**ADC Planning Consultation
Response from the Historic Buildings Adviser**

Application Number	BR/127/14/DOC
Address	104d Highfield Road Bognor Regis
Description	Application for approval of condition 2 or previously approved Listed Building application BR/203/14/L - relating to new windows
Case Officer	Anita Gardner
Site Visit

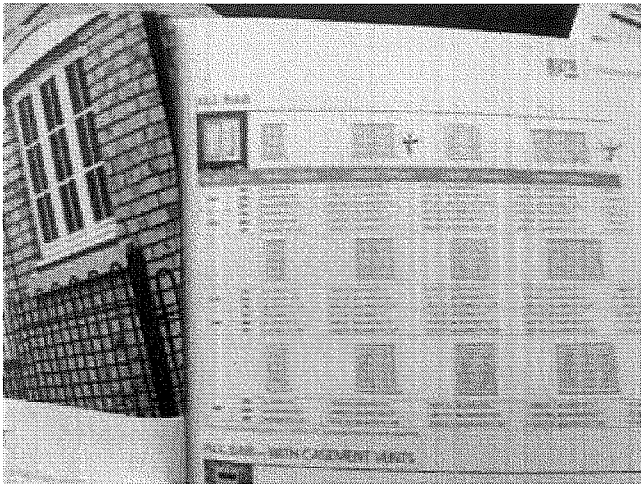
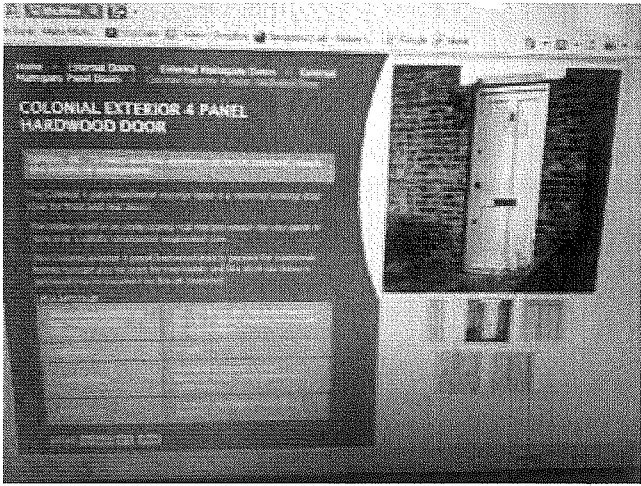
The information provided via photograph is unclear and therefore we are unable to comment clearly.

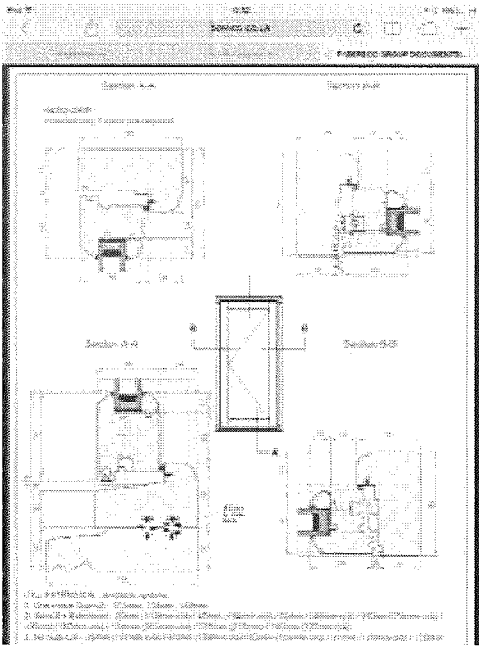
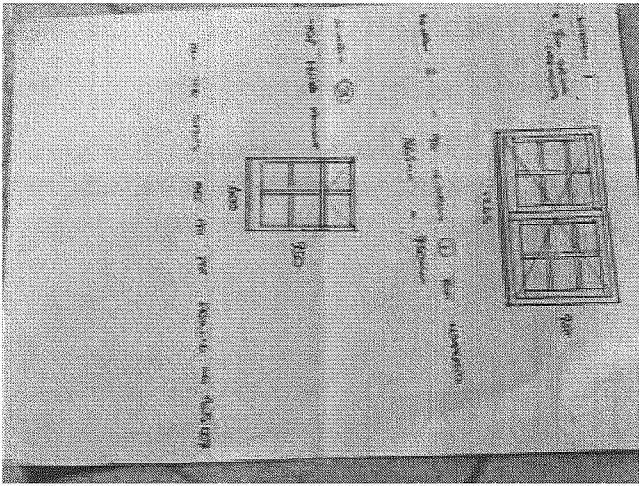
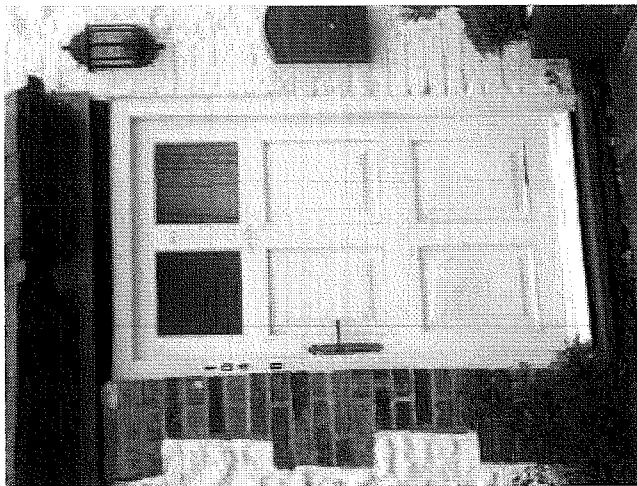
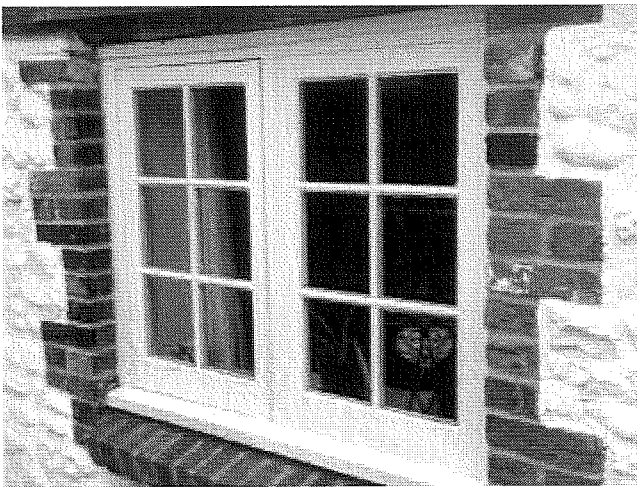
The drawing of the windows did not appear to correlate with the photograph provided. The panes are shown horizontal and not vertical. It was also unclear if these were to scale.

It was evident that double glazing was being applied for and if so, this should be a slim system (approx. 11mm).

Please note that the windows should be of traditional timber construction.
